From: [Marcus Ward](#)
To: [Rachael Stevie \(CD\)](#)
Cc: [Jeremy Johnston](#)
Subject: Re: VA-21-00003 Ward - Application on hold
Date: Monday, August 16, 2021 4:18:56 PM
Attachments: [image001.png](#)

I have sent my Staff Report to our Planning Official for review. He has stated that he does not see a convincing argument that the first two criteria have been met. These issues are noted below.

# BOUNDARY & TOPOGRAPHIC SURVEY

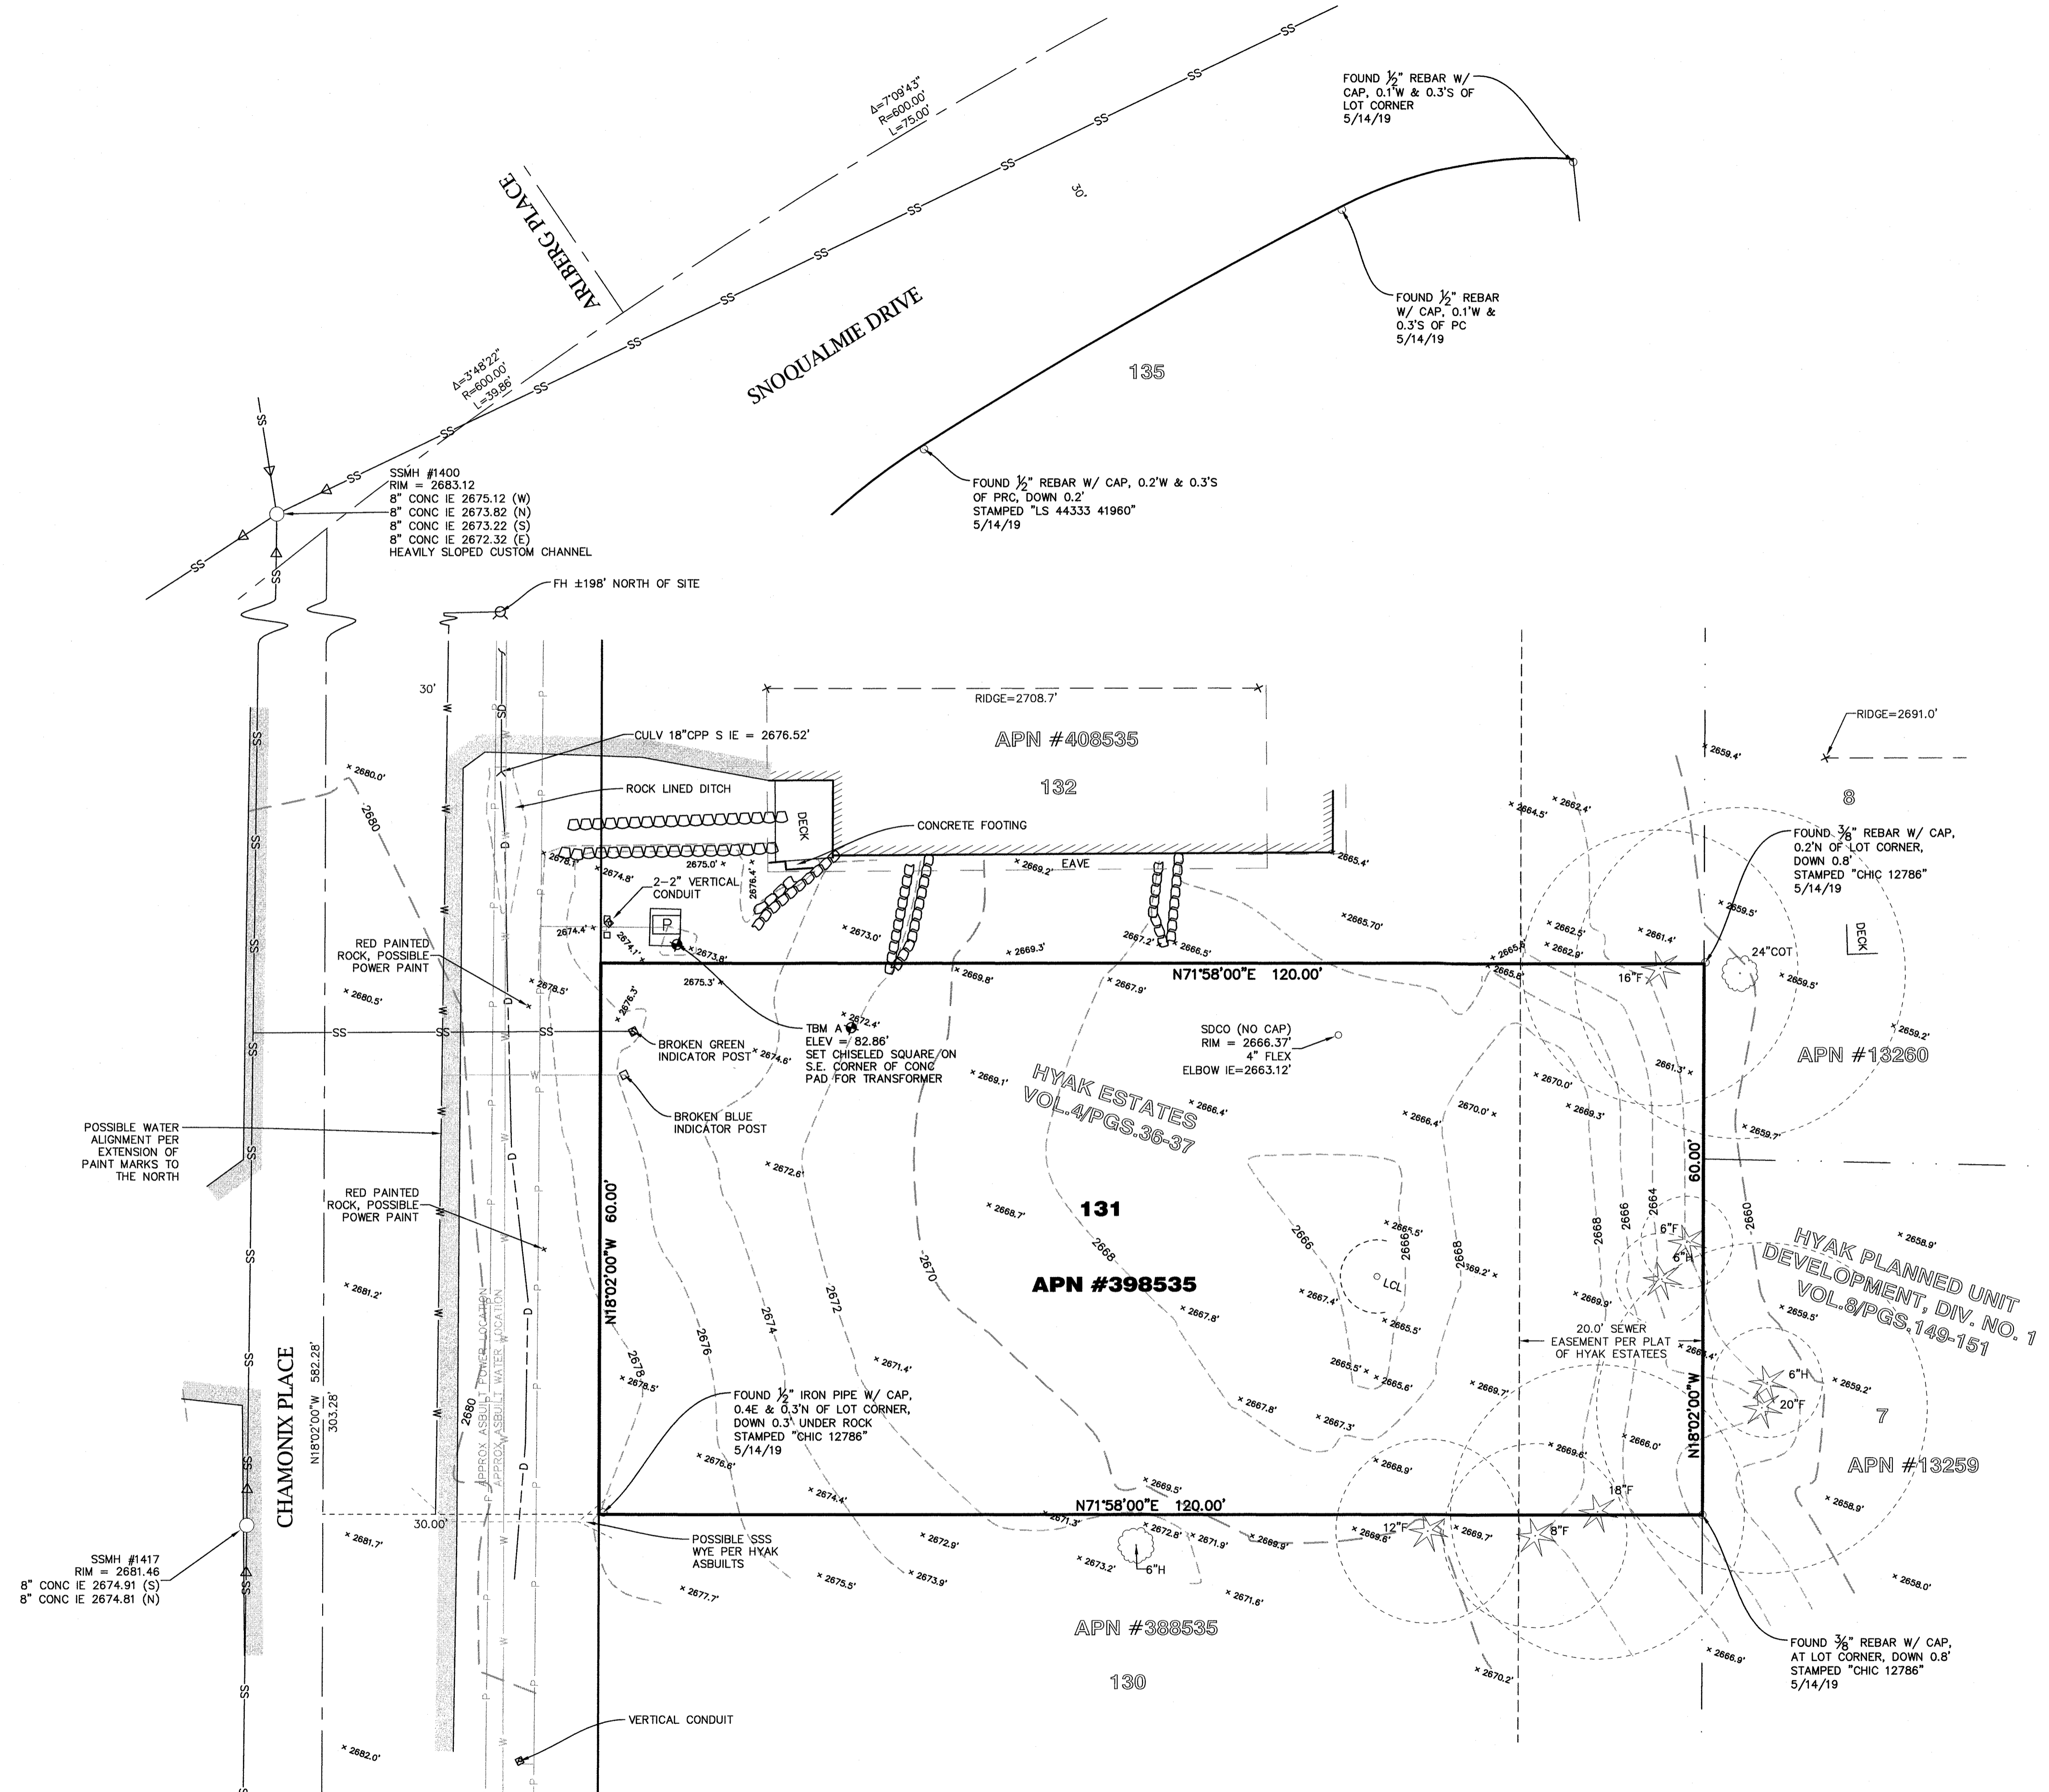
Based on County GIS slope data and the topographic survey you provided, it does not appear there are unusual circumstances relative to adjacent property owners. The slope does not appear excessive and seems generally consistent with neighboring parcels. The application states that the variance is necessary to obtain positive flow and gravity drain to the existing sewer, but no technical materials are provided to demonstrate this. This argument will need to be justified by a qualified engineer to be considered as evidence for consistency with criteria #1.

A. There has been significant and non-sanctioned alteration to my lot by the previous owner that has created unusual circumstances and topography that is not shared by adjacent lots. Evidence for this has been confirmed on the walk through today by comparing the topography and slope of my lot 131 and lot 130 directly south (this lot is undisturbed and in its natural state).

My lot includes a large berm of deposited earth on the east portion of the lot, a large depression in the center of the lot and evidence of grading on the southern lot line that includes exposed roots and clearly identifiable dozer tracks.
